Engineers Further Comments Regarding Condition 5

APPLICATION NO: BN/59/19/DOC

Site Address: Land Adjacent 4 Lake Lane Barnham PO22 0AD

Category: Discharge of Condi
Description of Works: Approval of details reserved by condtion imposed under ref
BN/23/15/PL relating to Condition Nos 5 - surface water drainage, 6 -
consent for discharge of any flows to watercourses, 7 - future access
& maintenance of watercourses or culverts.

|        | 4 Lake Lane<br>Barnham<br>West Sussex | Surface water<br>drainage plan | Planning    | CB       | CB             |

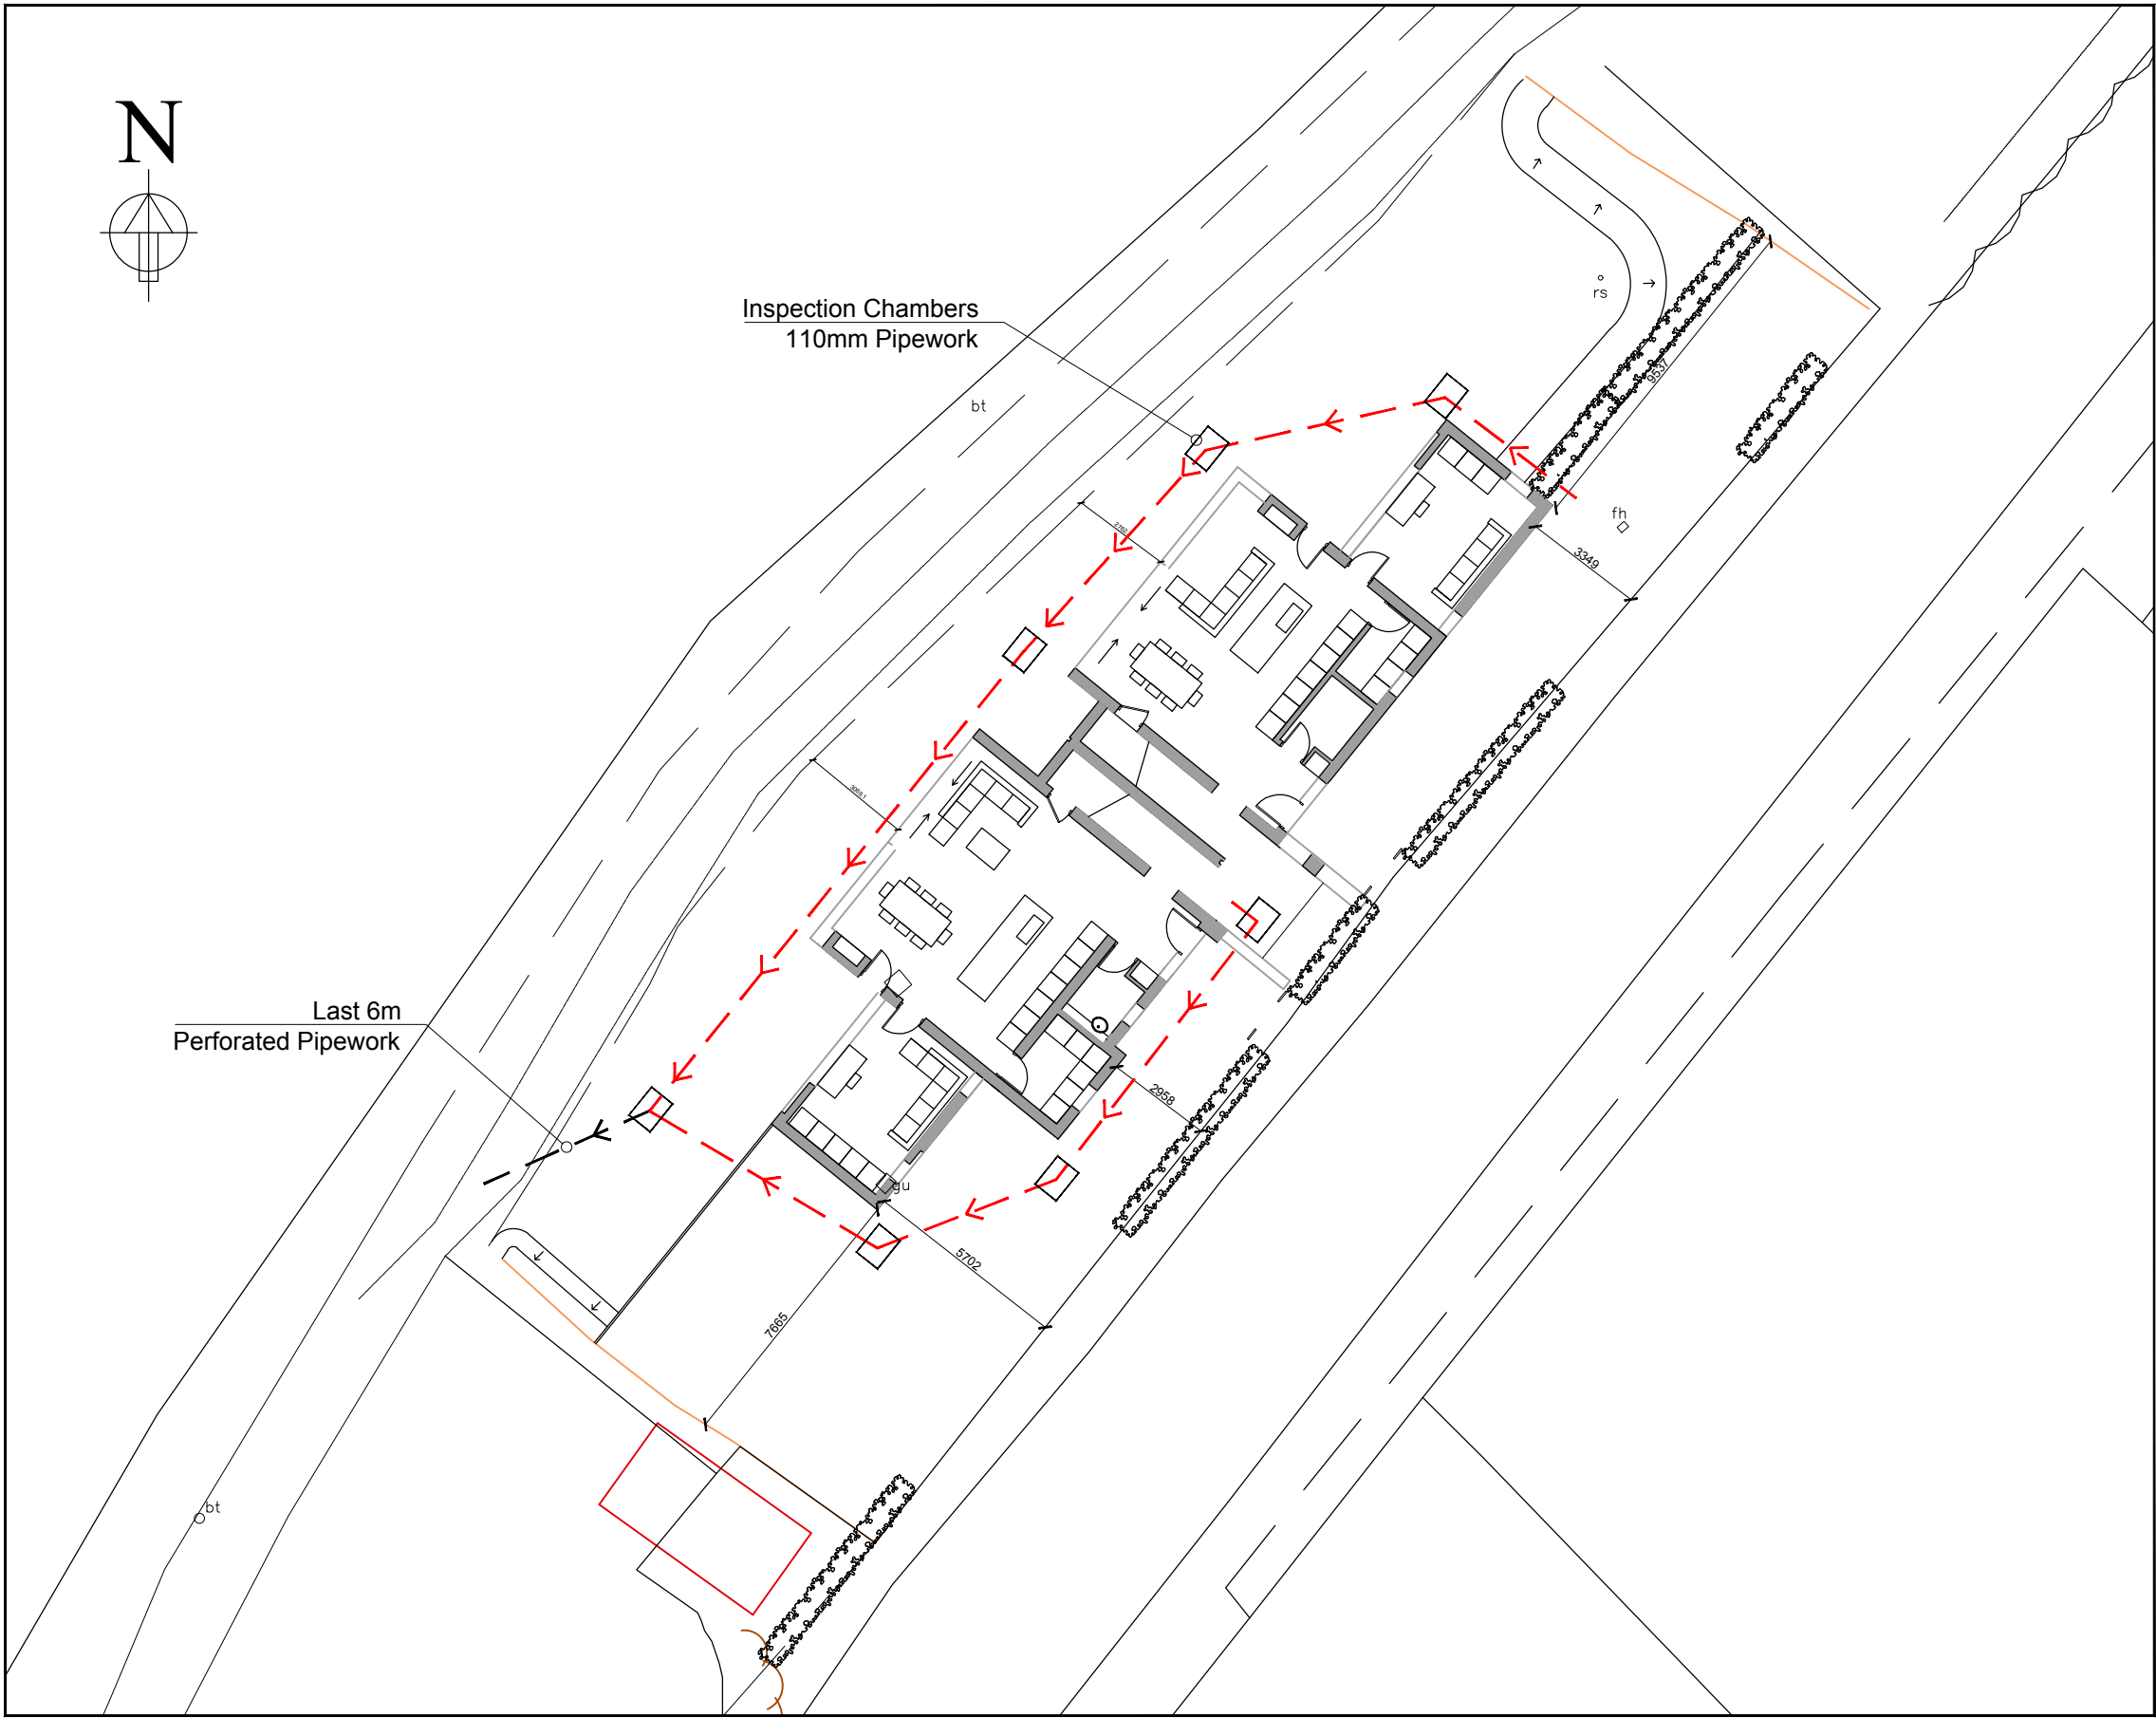
Our checklist has been submitted. Within the checklist it is indicated that no groundwater monitoring or infiltration testing has been completed and that justification has been provided for not using infiltration. Please can this justification be provided.
